**PROPOSED PAILET REPAIR
YARD AND SITING OF
OFFICE PORTACABIN**

**PROPOSED NEW VEHICULAR
ACCESS AND VISIBILITY SPLAYS.
AREA FOR EXTERNAL PAILET
STORAGE TO BE LIMITED TO
EASTERN BOUNDARY ONLY
PROPOSALS FOR NEW LANDSCAPED
AREAS.**

2704 - 1 A

TOWN & COUNTRY PLANNING (GENERAL DEVELOPMENT PROCEDURE)
ORDER 1995. APPLICATION NO. H03/0511/96. BAR FARM, LITTLEWORTH
DROVE, SPALDING - PROPOSED PALLET REPAIR YARD AND SITING OF
OFFICE PORTACABIN

BLOCK PLAN 1:500

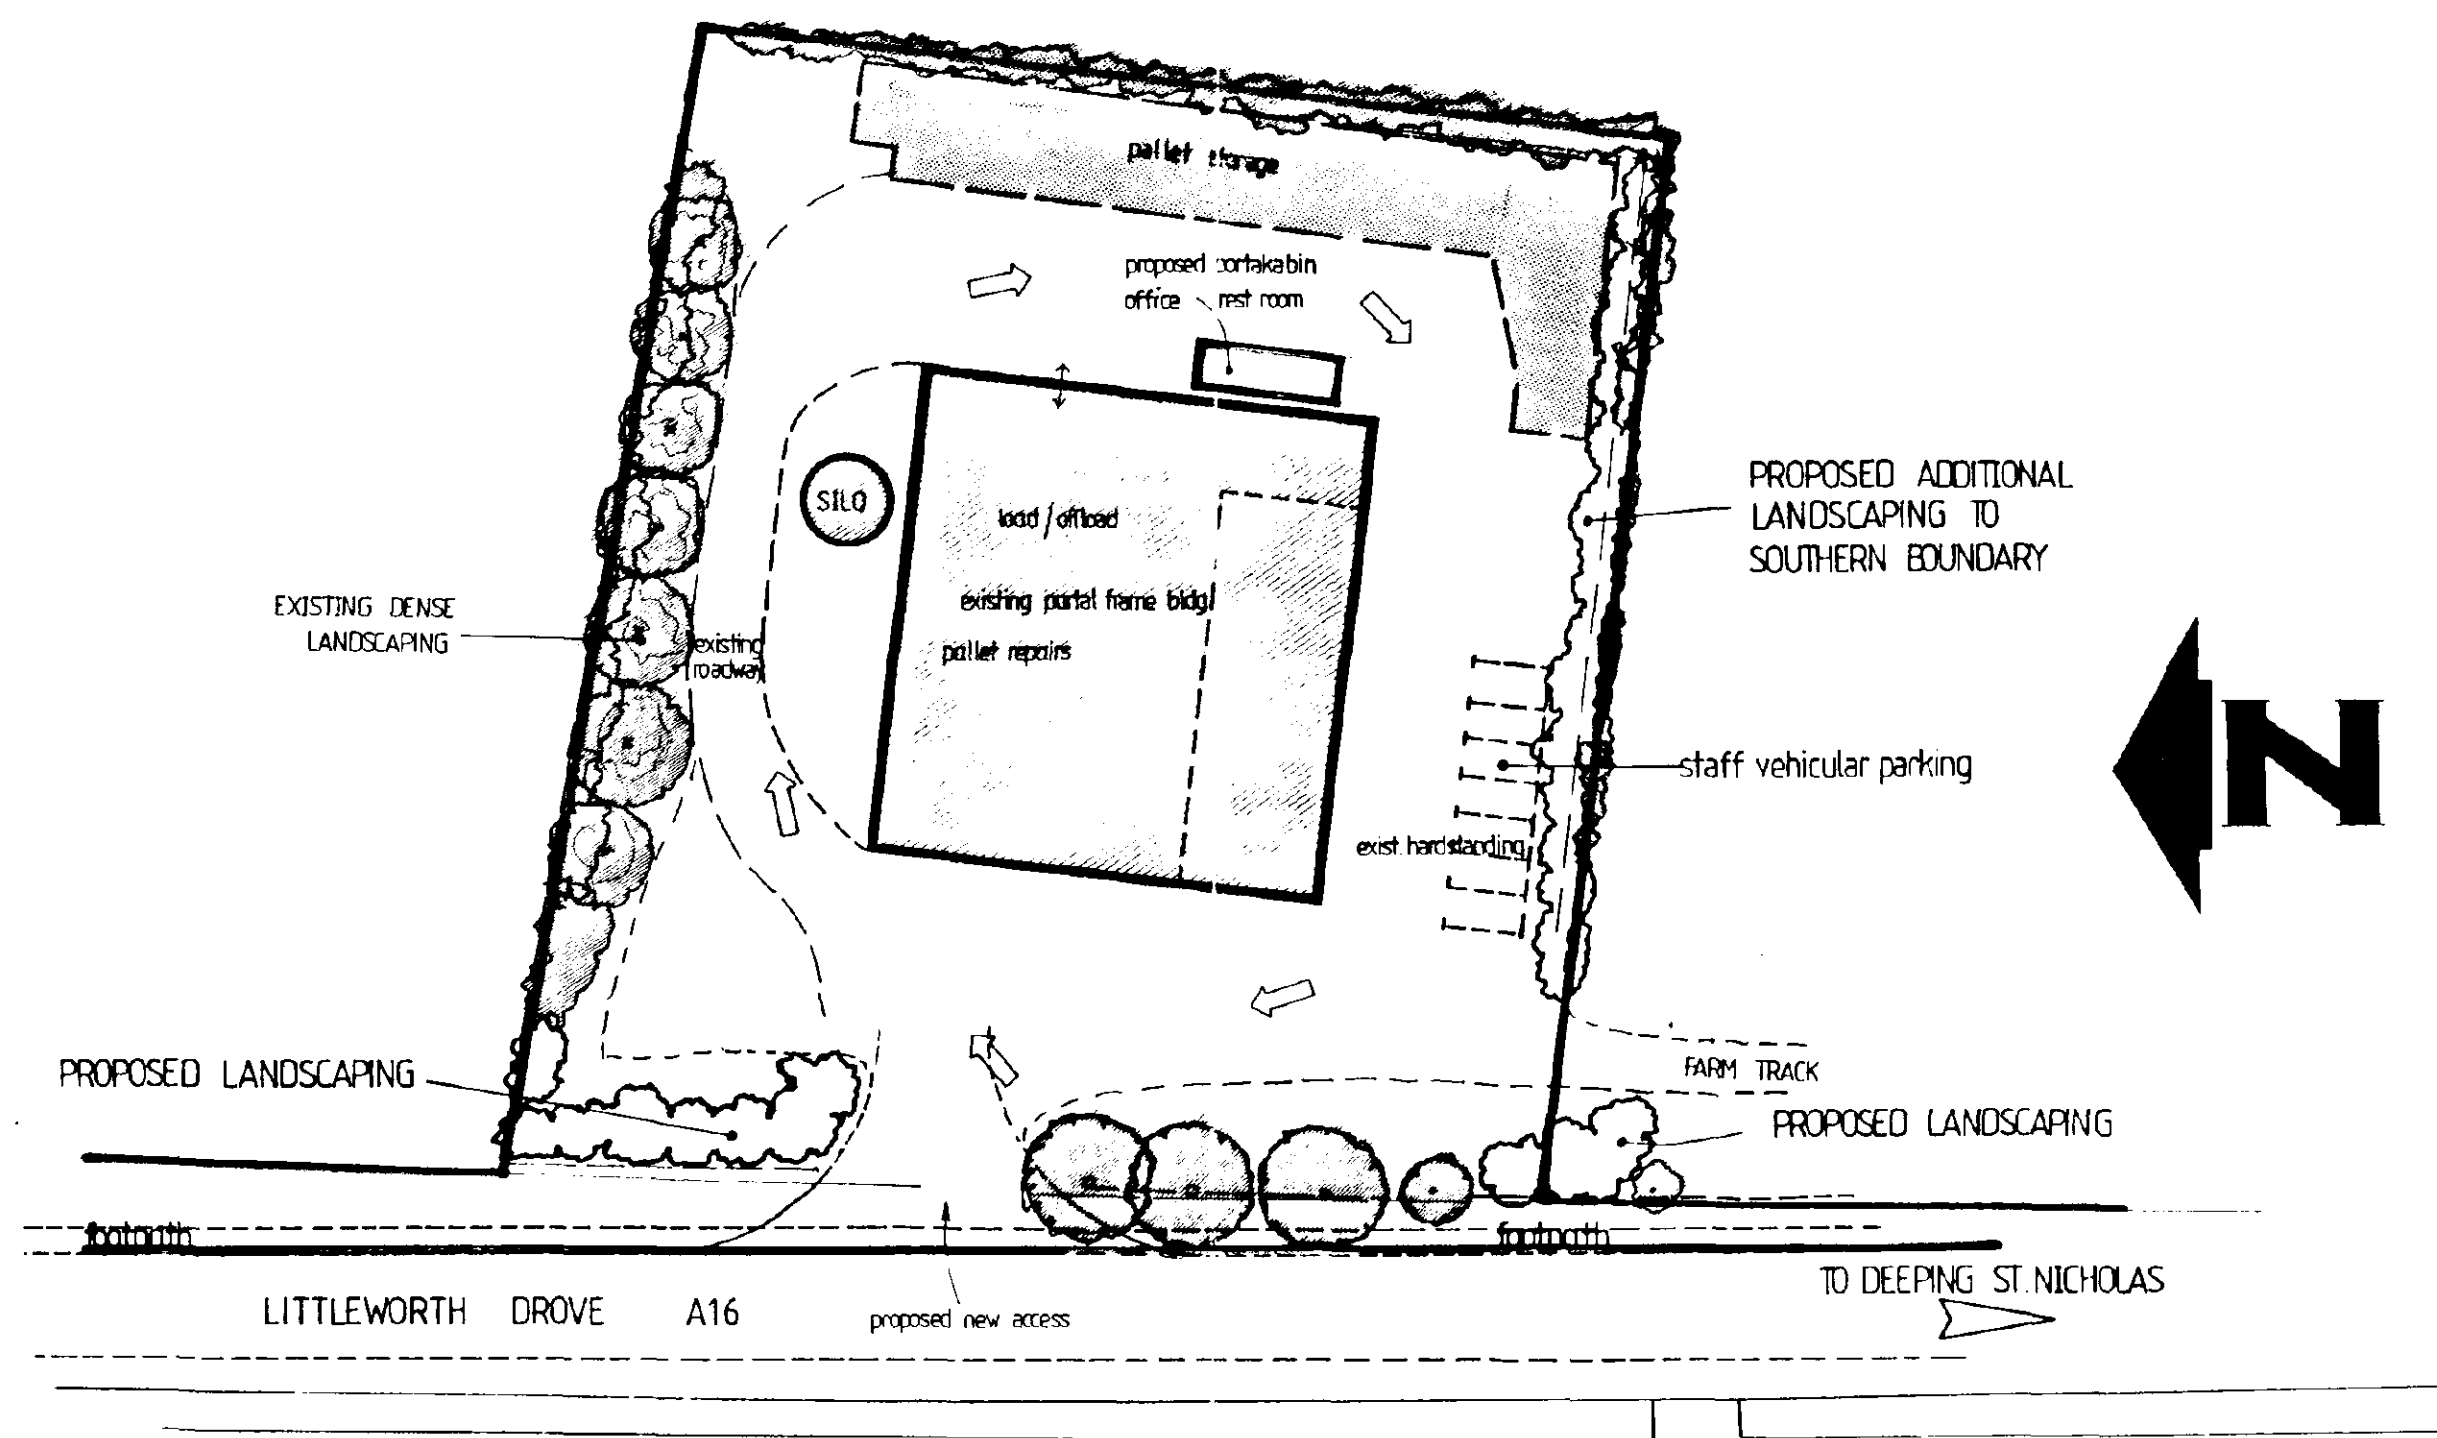
Pallets on right obvious for A16 - unlikely
offensive.

Those proposed to be stored on left well screened
by trees around parking lake.

Suggest parking moved to right + pallets
stored from A16 as possible

Need a height limit especially on any
storage on right hand side

- 3 SC27 - (Implementation of planting)
- 4 Within a period of three months from the date of this permission the pallets stored on site shall be relocated to the area shown on the submitted plan and thereafter pallet storage on the site shall only be within the area marked on the submitted plan. Pallets stored within this area shall not exceed three metres in height.
Reason: In the interests of visual amenity.

ACCESS VISIBILITY SPLAY PLAN 1:500

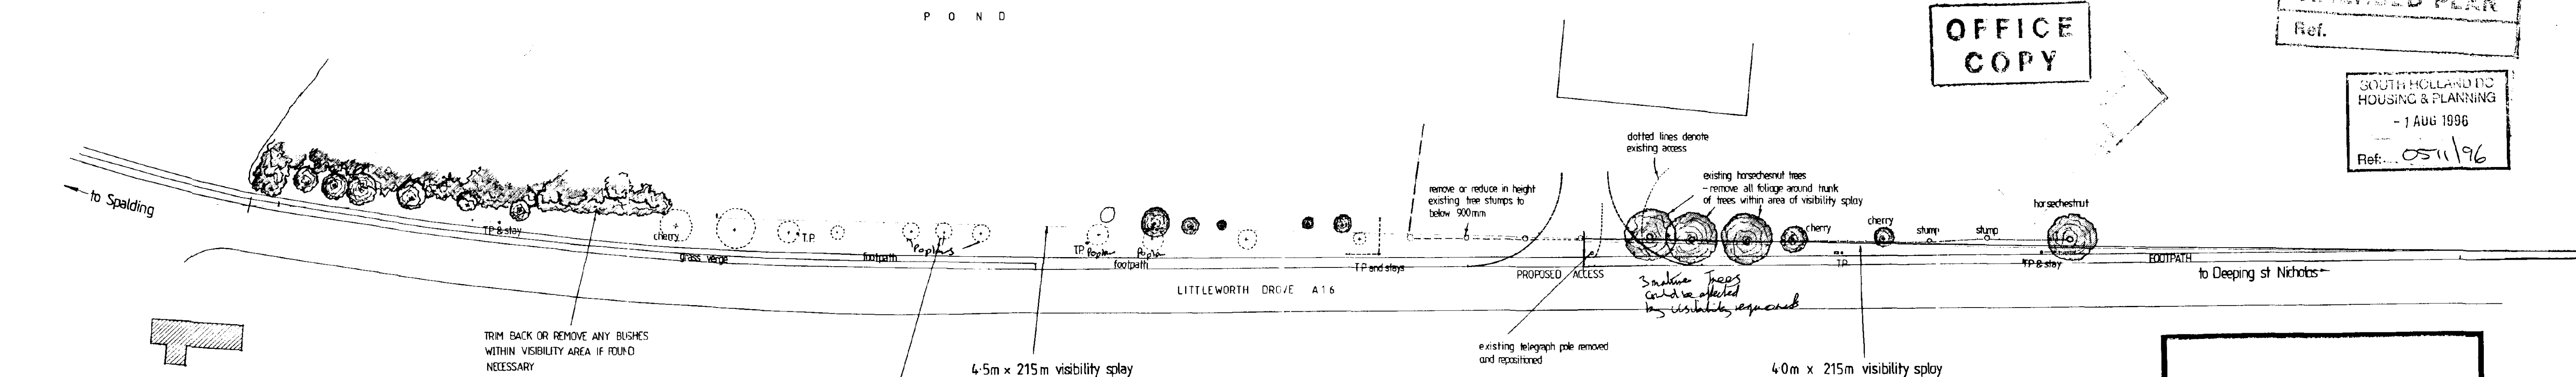
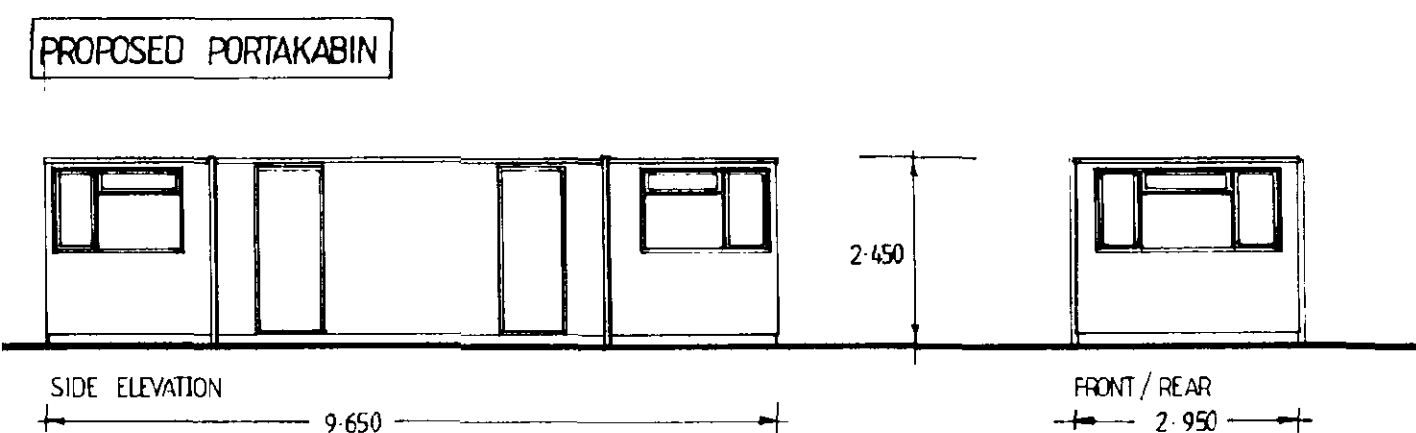
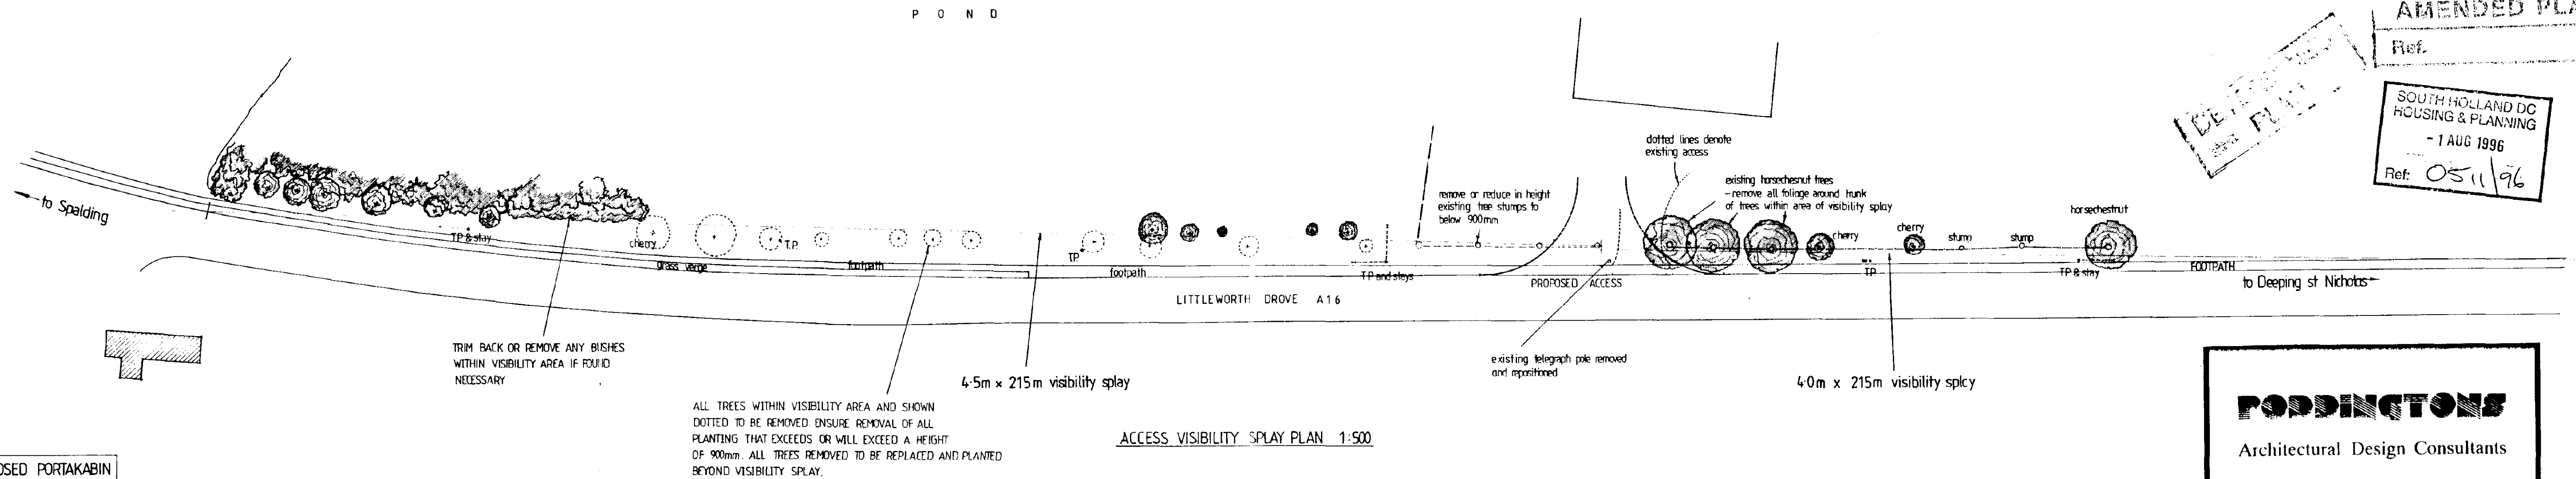
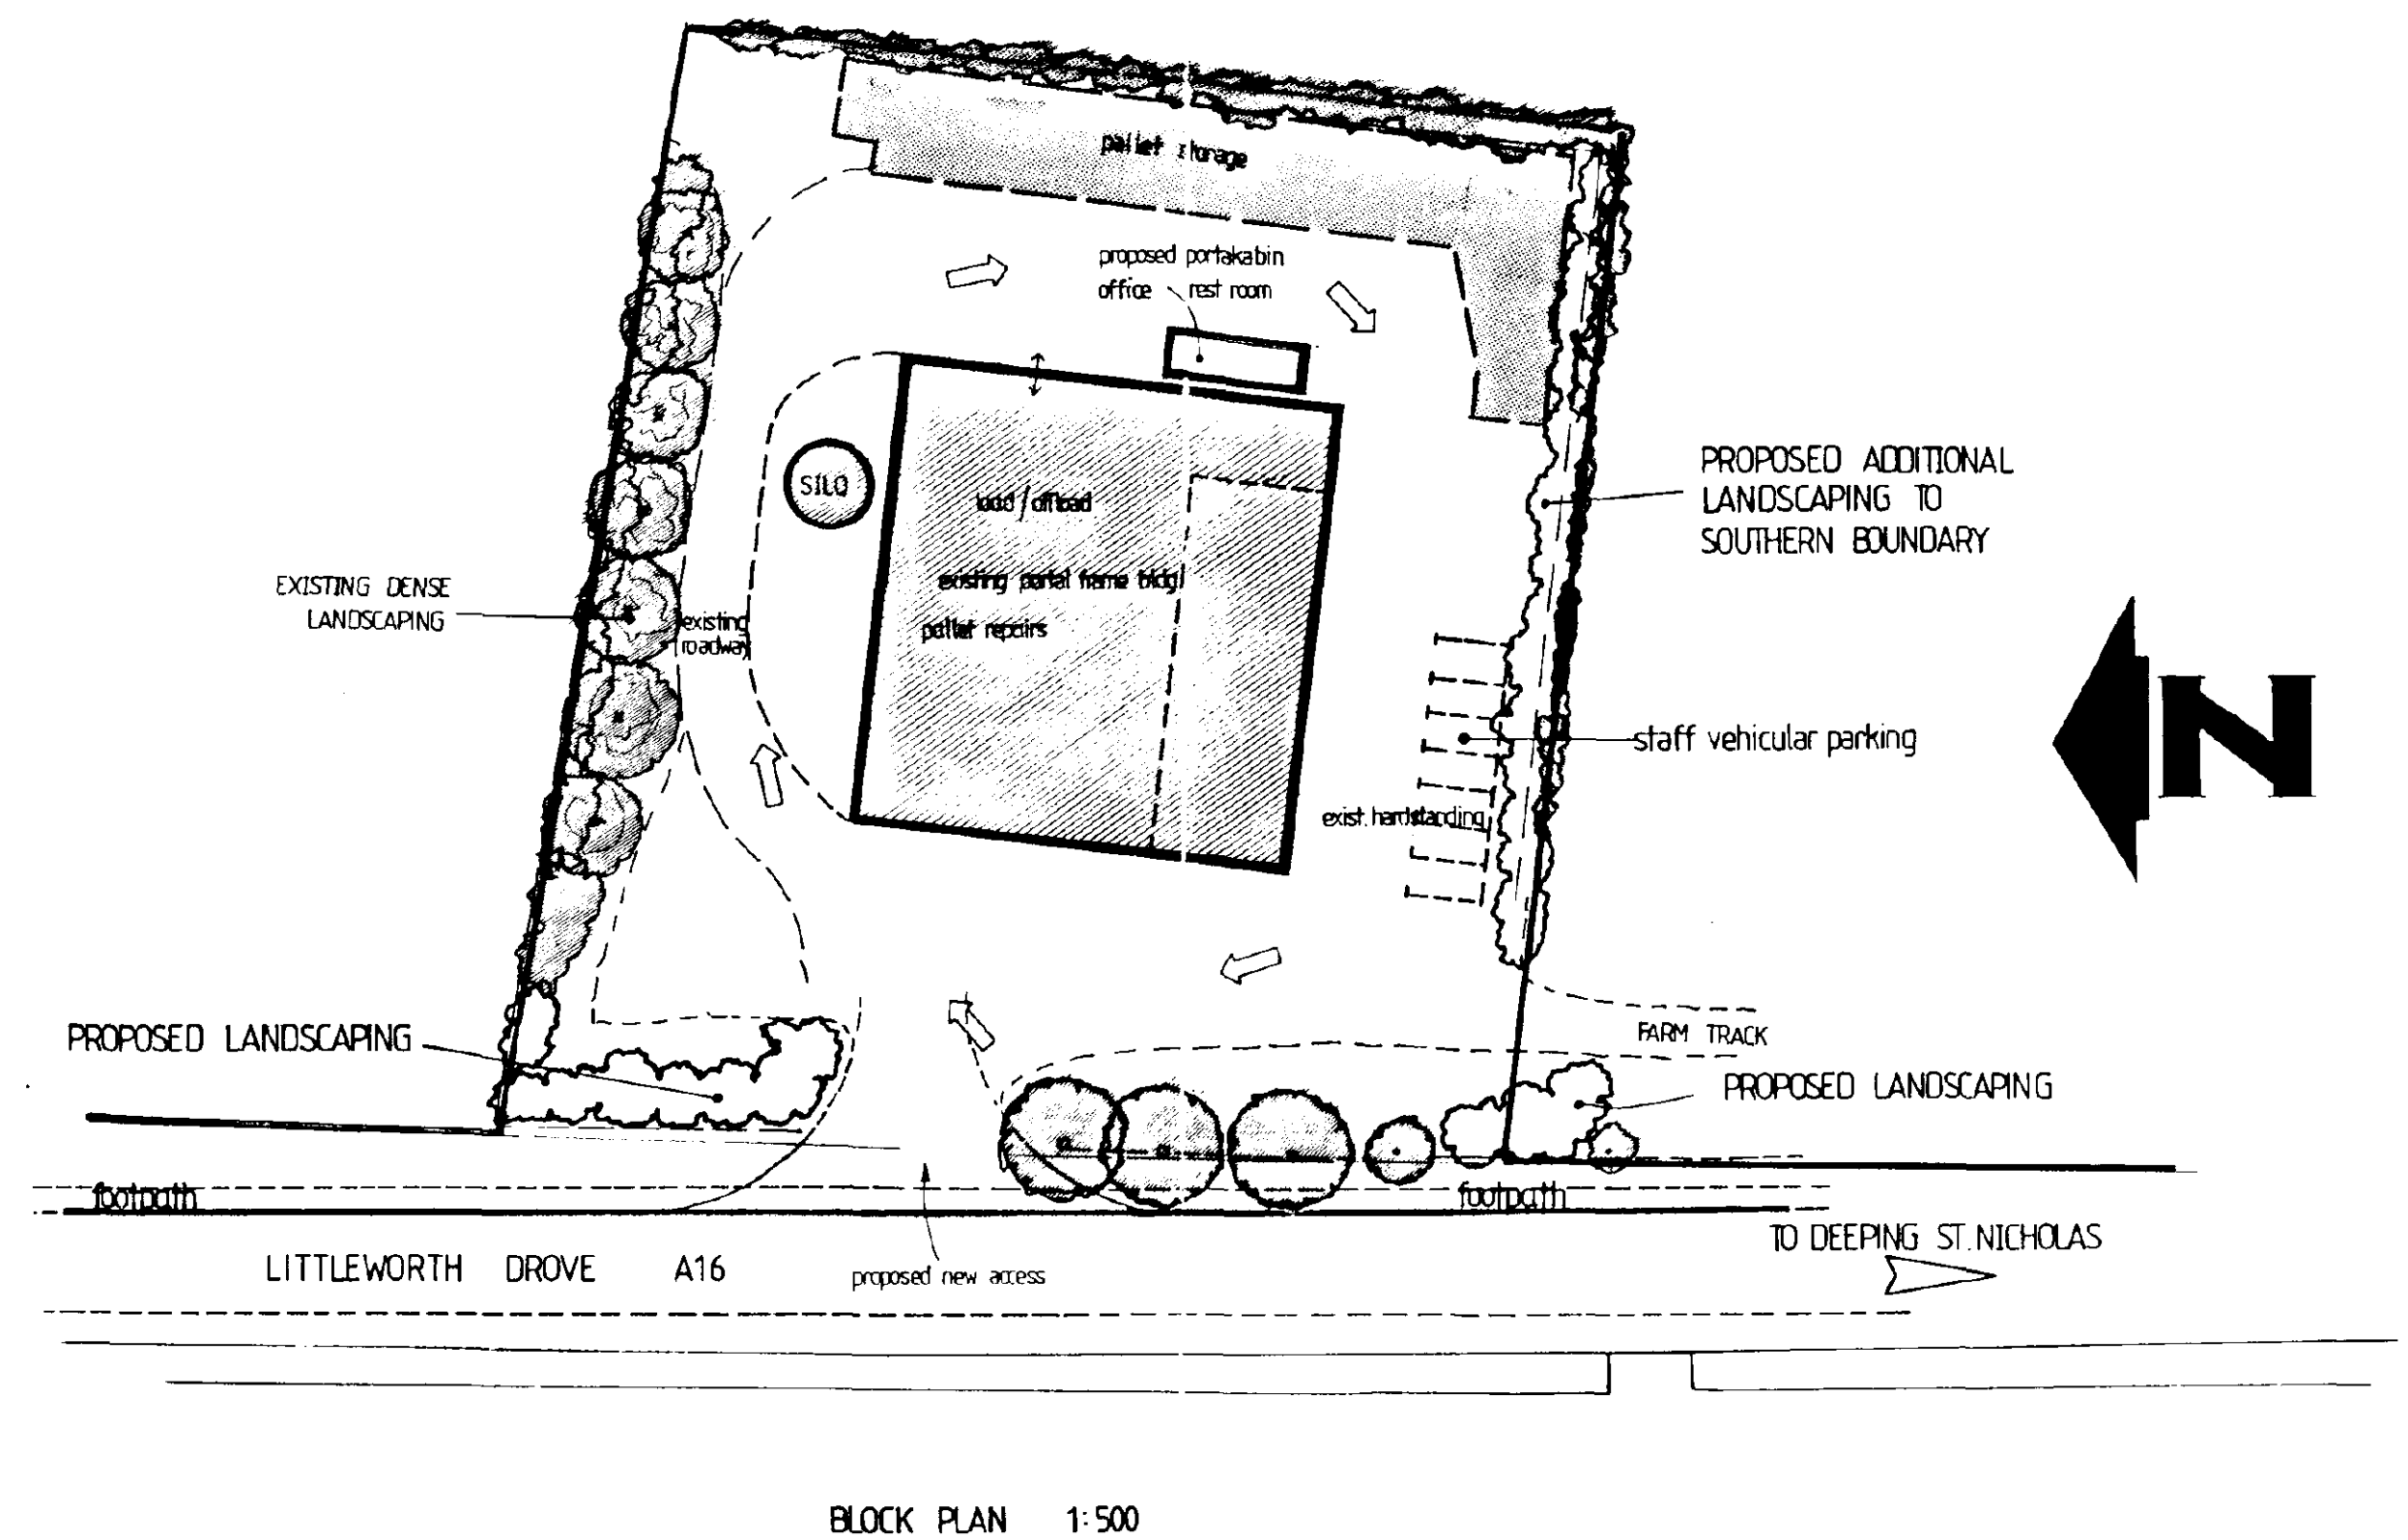
I refer to your letter of 5 September 1996 in connection with the above planning application in which you request permission to relax the visibility splays at the above site from 4.5 metres to 4.0 metres in the southern direction.

The Applicant has amended the drawing to show the effect of your conditions on the proposal and I enclose a copy for your information. The site is fronted by 3 mature horsechestnut trees which will need to be removed if the visibility splay is 4.5 metres deep. I therefore write to ask whether you would be prepared to relax the visibility to 4.0 metres in the southern direction which should enable these trees to be retained. It is possible to provide a 4.5 metre deep visibility splay to the north which is the traffic approach direction.

20-8 4.5m requires all materials removing
3.5 → 4.0m maybe ok but low level stuff needs removing

I confirm that the Highway Agency have no objections to these proposals.
